Our ref: NO/2012/104135/01-L01

Date: 29 August 2012

**DISCHARGE CONDITION 3, 4, 7, 8, 9, 10, 12, 13 AND 14 OF PLANNING
PERMISSION 3/2011/0837
LAND OFF PENDLE DRIVE, WHALLEY, LANCASHIRE**

Drawing Title
Adoptable Drainage Layout

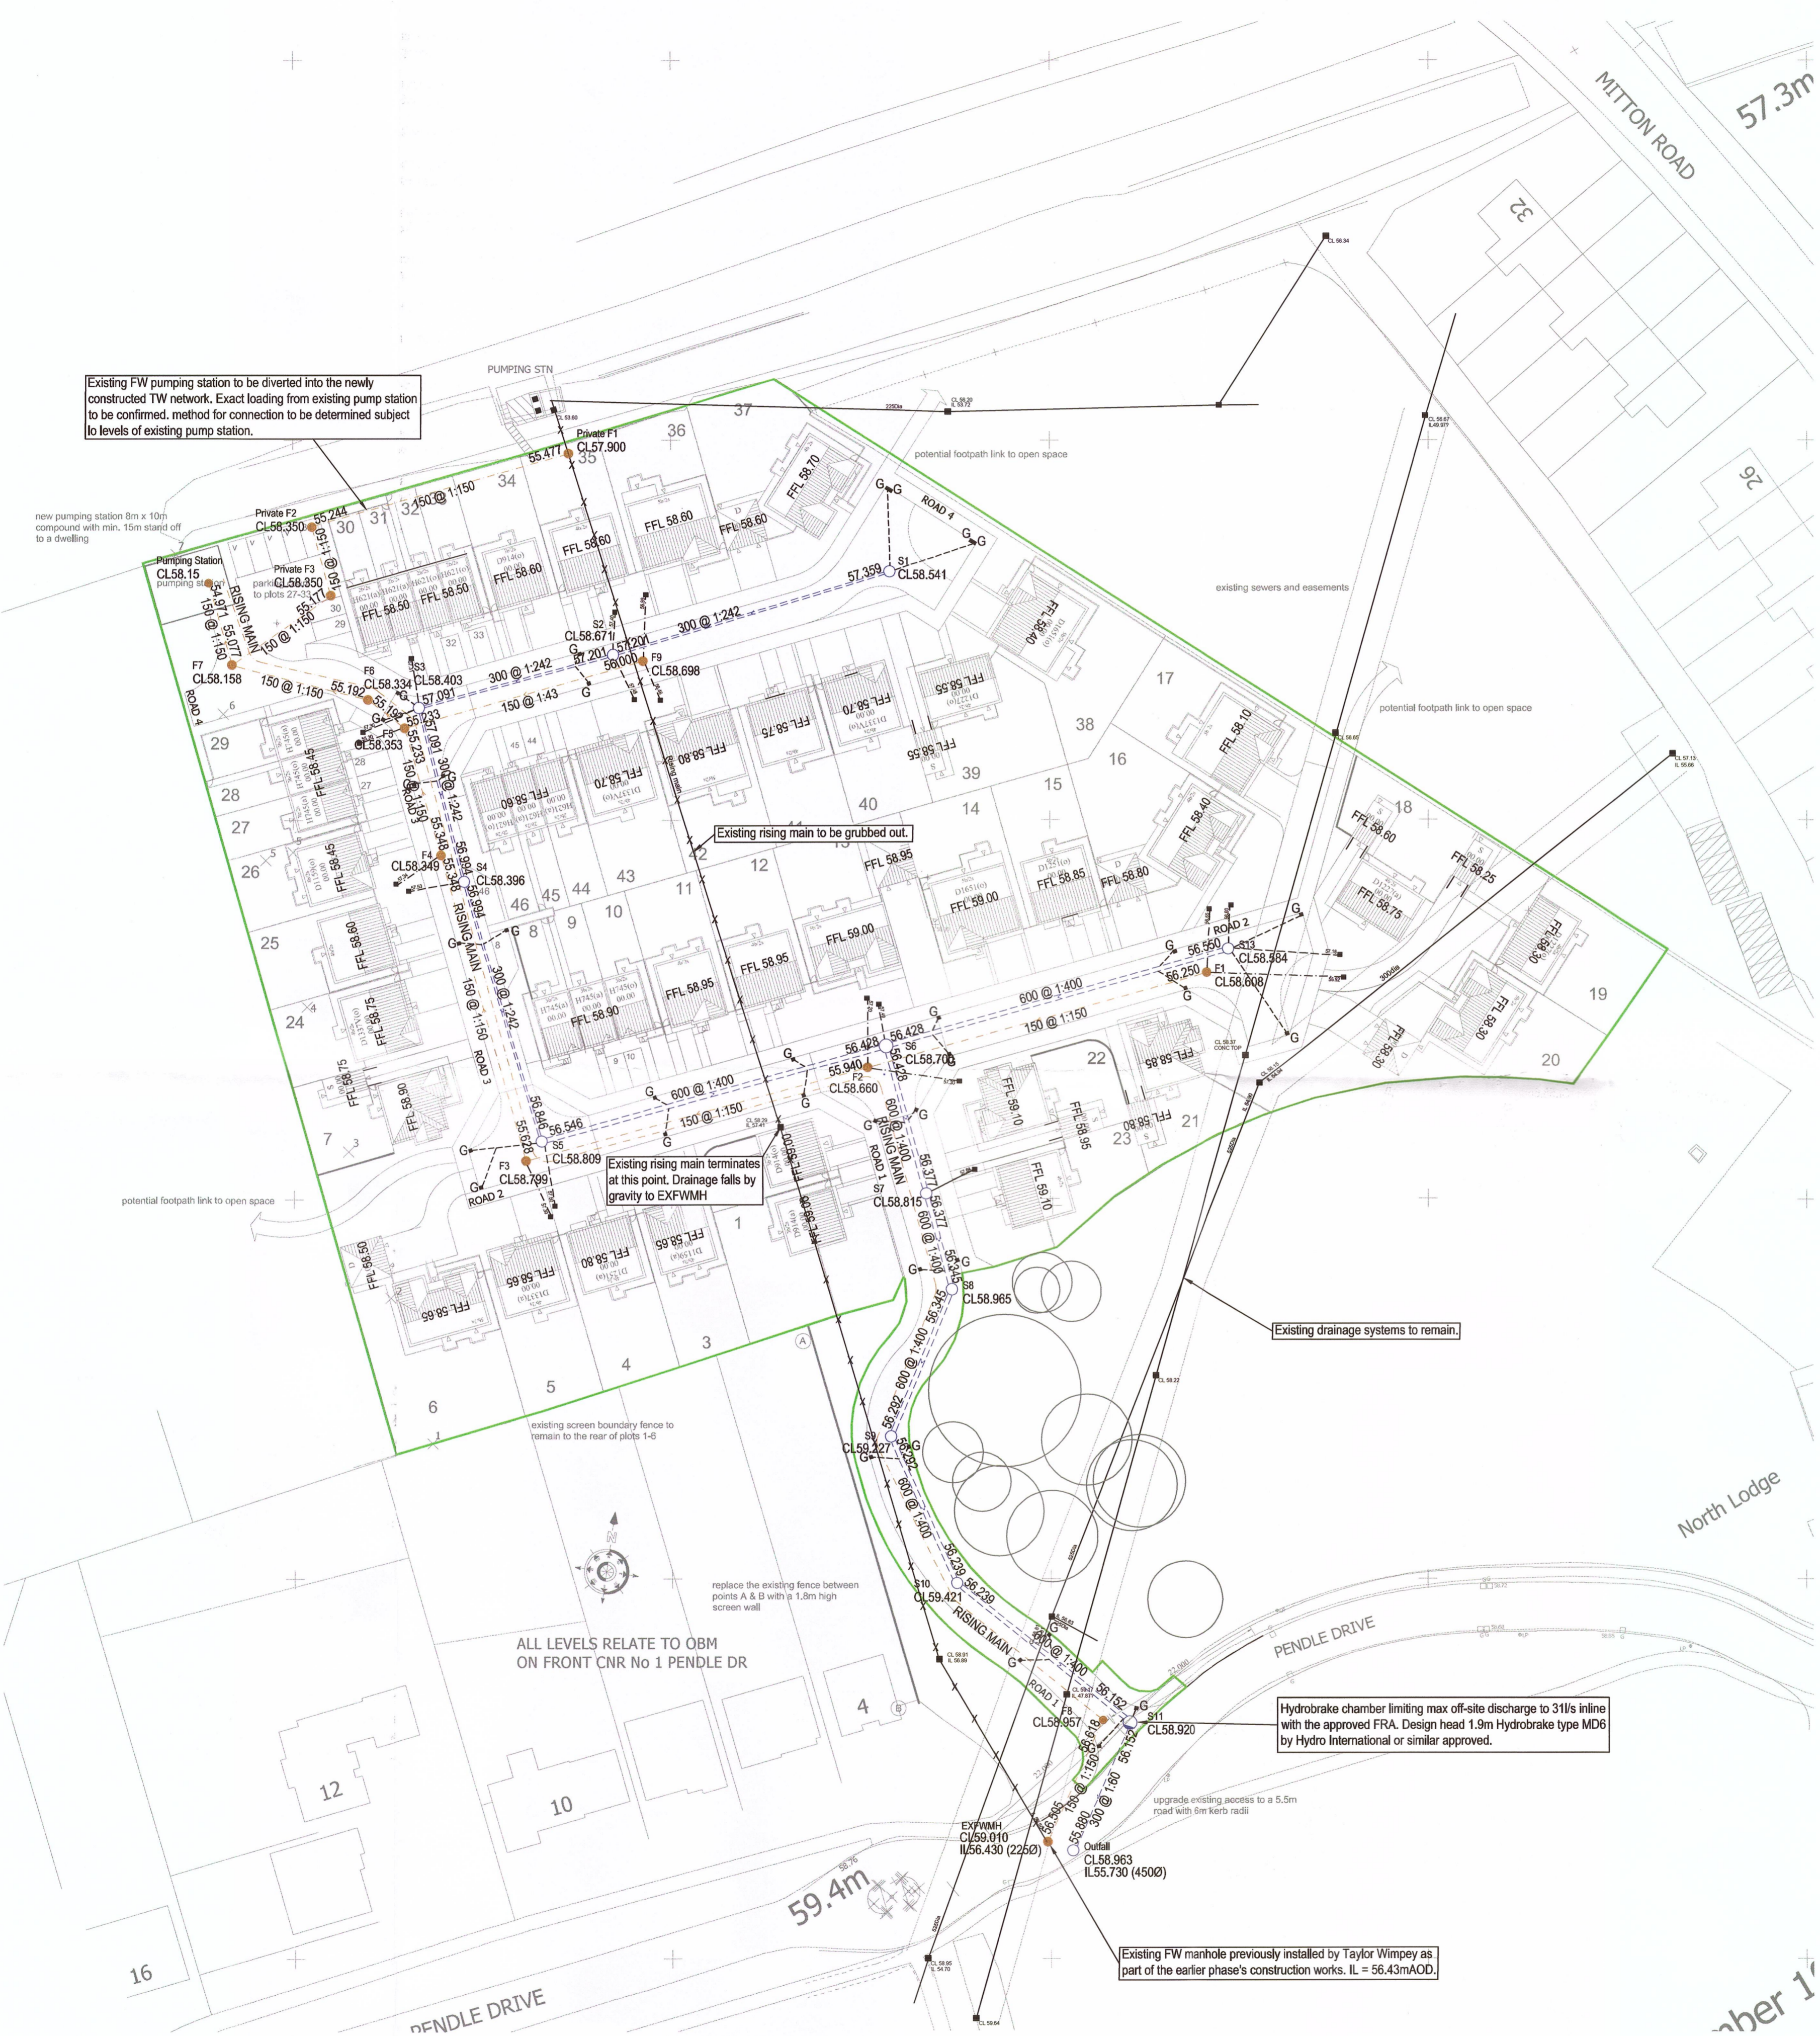
We are unable to comment on the discharge of these conditions as no hydraulic calculations have been submitted also the surface water discharge seems particularly high at 31l/sec.

We would therefore recommend that these conditions are not discharged until such times as additional information has been submitted.
